**Residential Building R5 (SSD-6966) Mod-2
Request for additional information
Barangaroo South**

This letter provides a response to the above request for additional information relating to modification application SSD 6966 R5 (Mod 2). The request for additional information is outlined below in italics:

R5
PLAN BASEMENT LEVEL B2

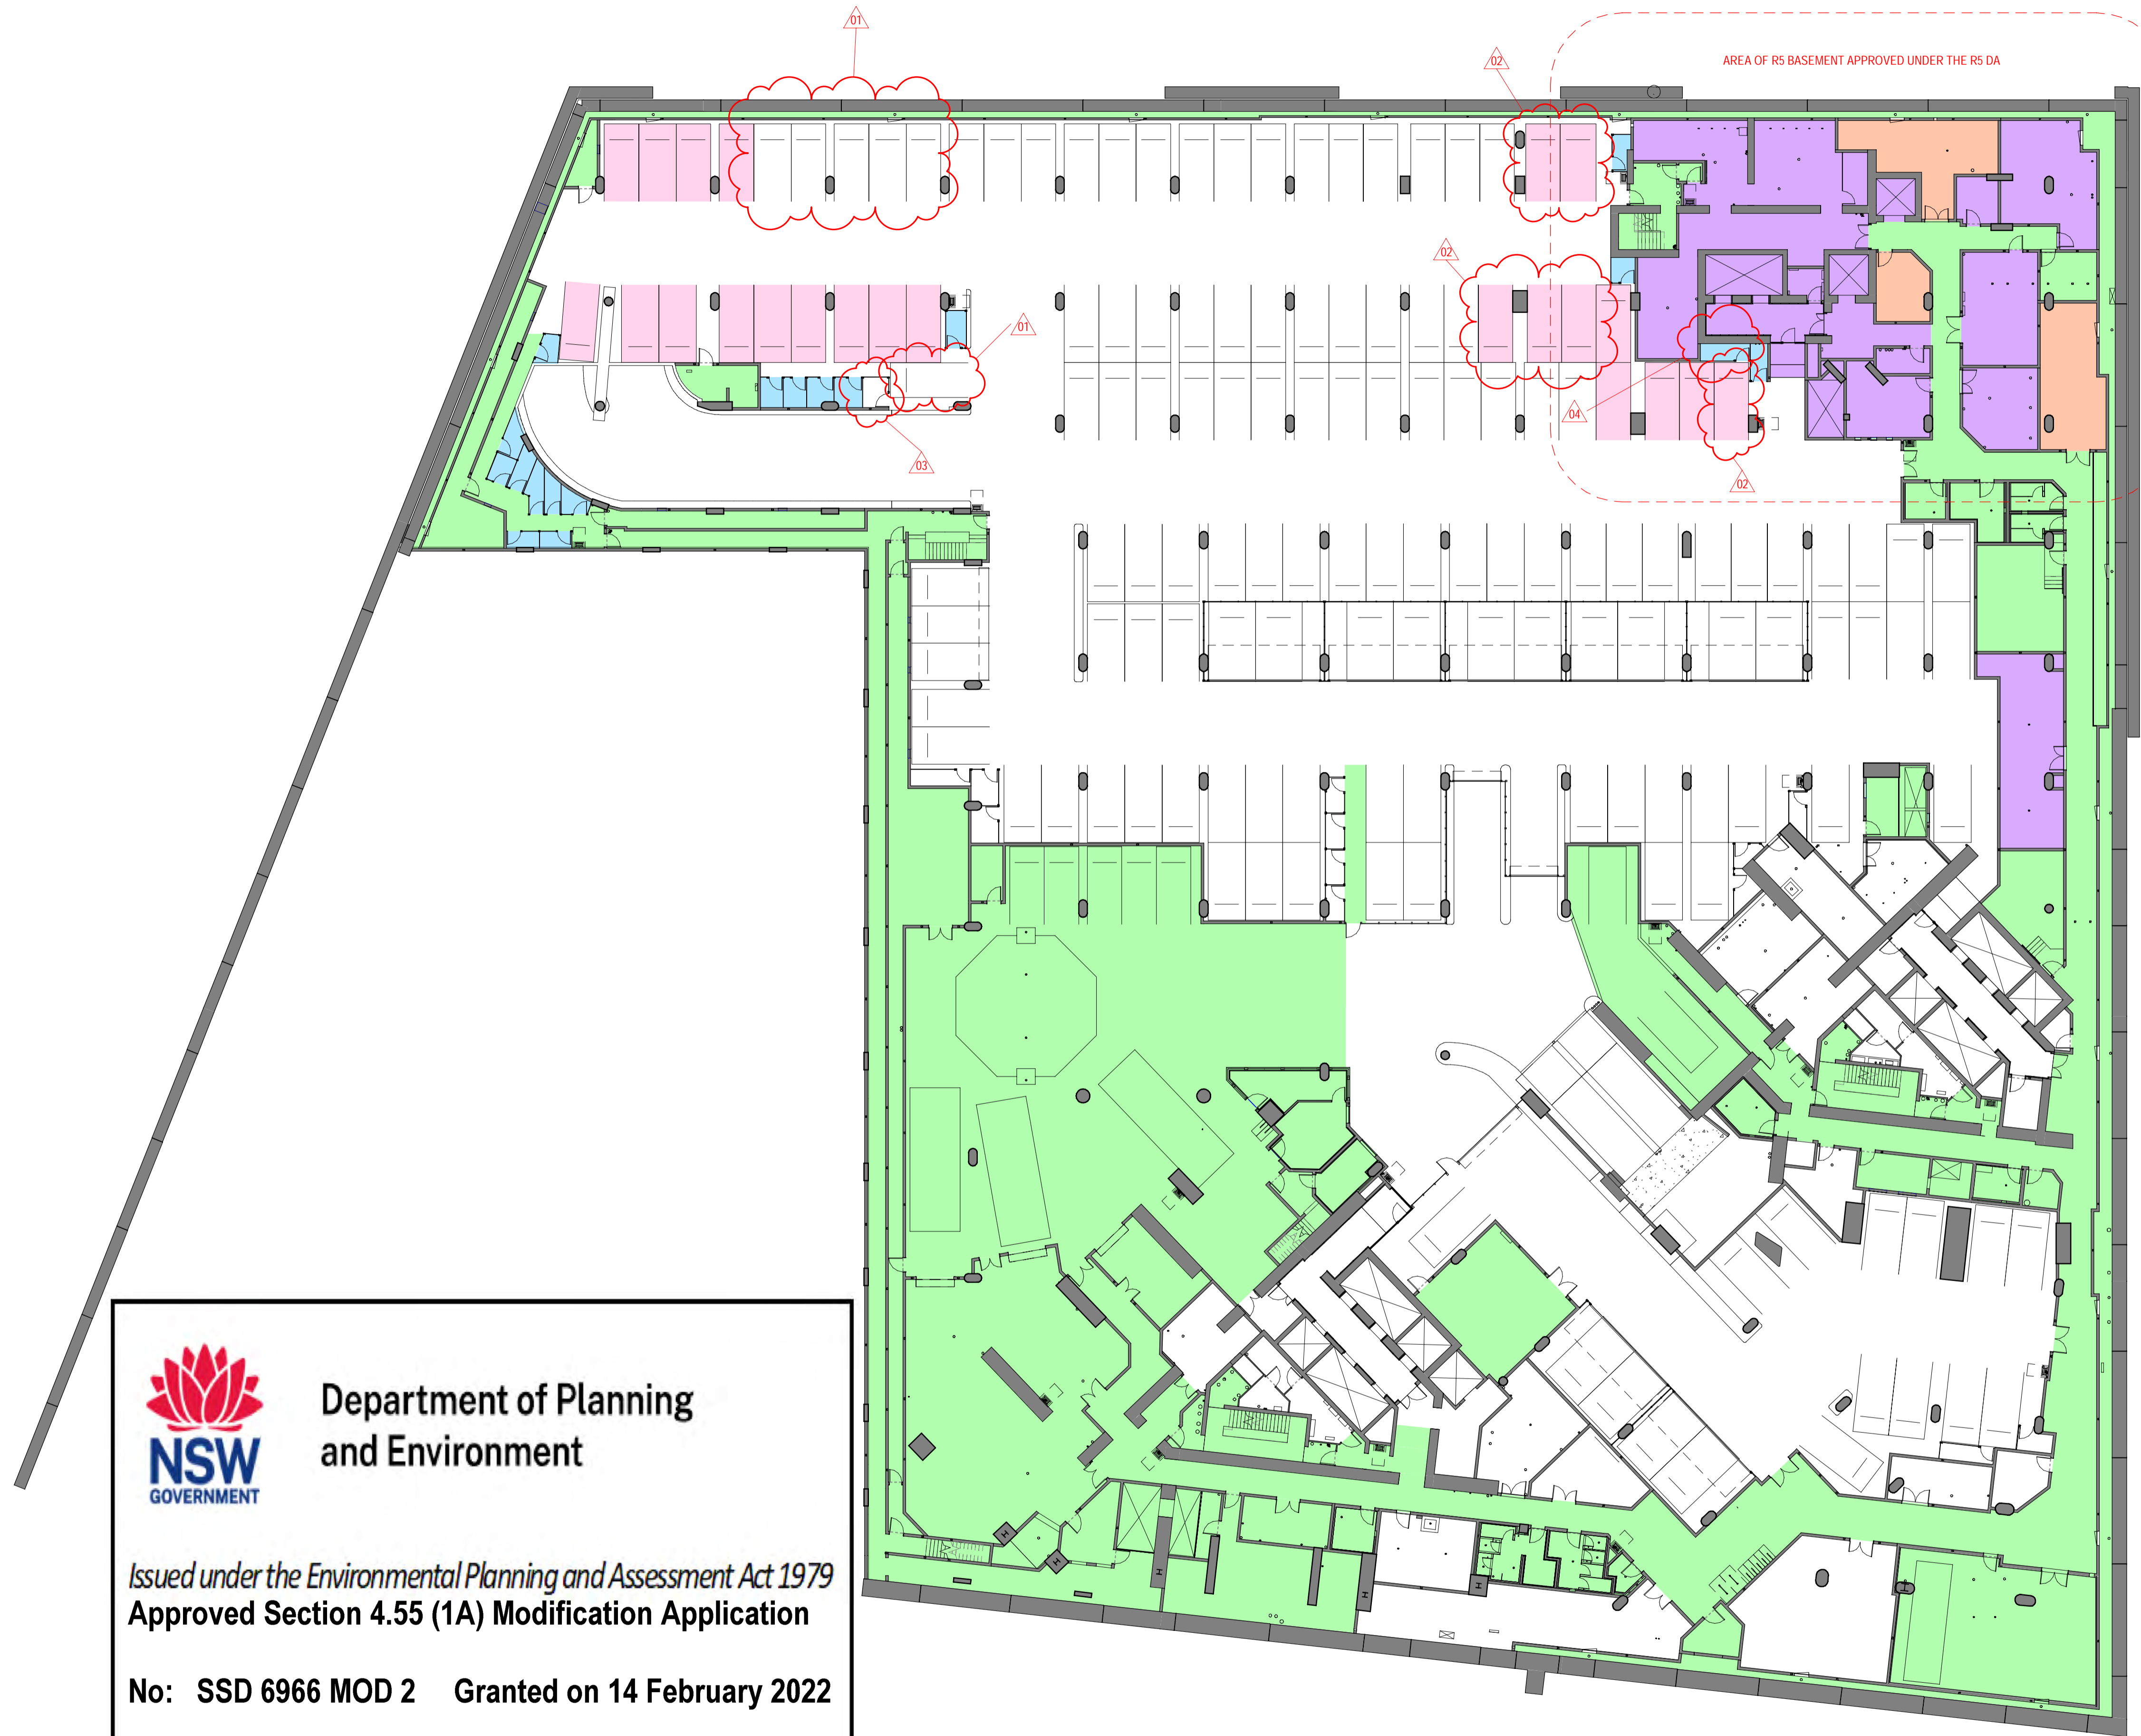
Confirm the reallocation of storage cages between Building R4A and R5 on Level B2, noting the modification report for R5 describes the proposed change as:

Level B2: Reallocation of associated storage cages between Building R5 and Building R4A.

where as the plans for R5 (Drawing No BR5_ASD_PA1_1003 R5 Plan Basement Level B2 dated 21.10.21) show:

- 1. Three storage cages allocated to R4A from R5 in the north-east corner of the basement (annotated 3)*
- 2. Two storage cages allocated to R5 from R4A in the south-east corner of the basement (annotated 5)*

Confirm if there is an overall increase/decrease or no change to storage cages for R4A and R5.

1. Three storage cages are proposed to be allocated to R4A from R5 in the north-east corner of the basement (annotated 3 on the drawings), refer to Figure 1.
2. Two storage cages are proposed to be allocated to R5 from R4A in the south-east corner of the basement (annotated 4 on the drawings), refer to Figure 1.

The reallocation of storage cages between R4A and R5 is required to accompany the proposed reallocation of car spaces between R4A and R5. This is due to the access for these storage cages being through/near the proposed reallocated car spaces. Therefore, the reallocation supports their spatial distribution per the subject building area in the basement.

With respect to resulting storage cages for Building R5, under the modification application(s) there are three storage cages allocated to R4A from R5, and two storage cages allocated to R5 from R4A. This represents an increase of one storage cage for R4A and therefore a decrease of one storage cage for R5. The modification does not impact on Building R5's compliance with the storage requirements under the ADG (being 4G). There is no change to storage located within apartments, as required. The minor reduction in storage cages (by one cage) does not affect the available provision of additional storage located within the basement.
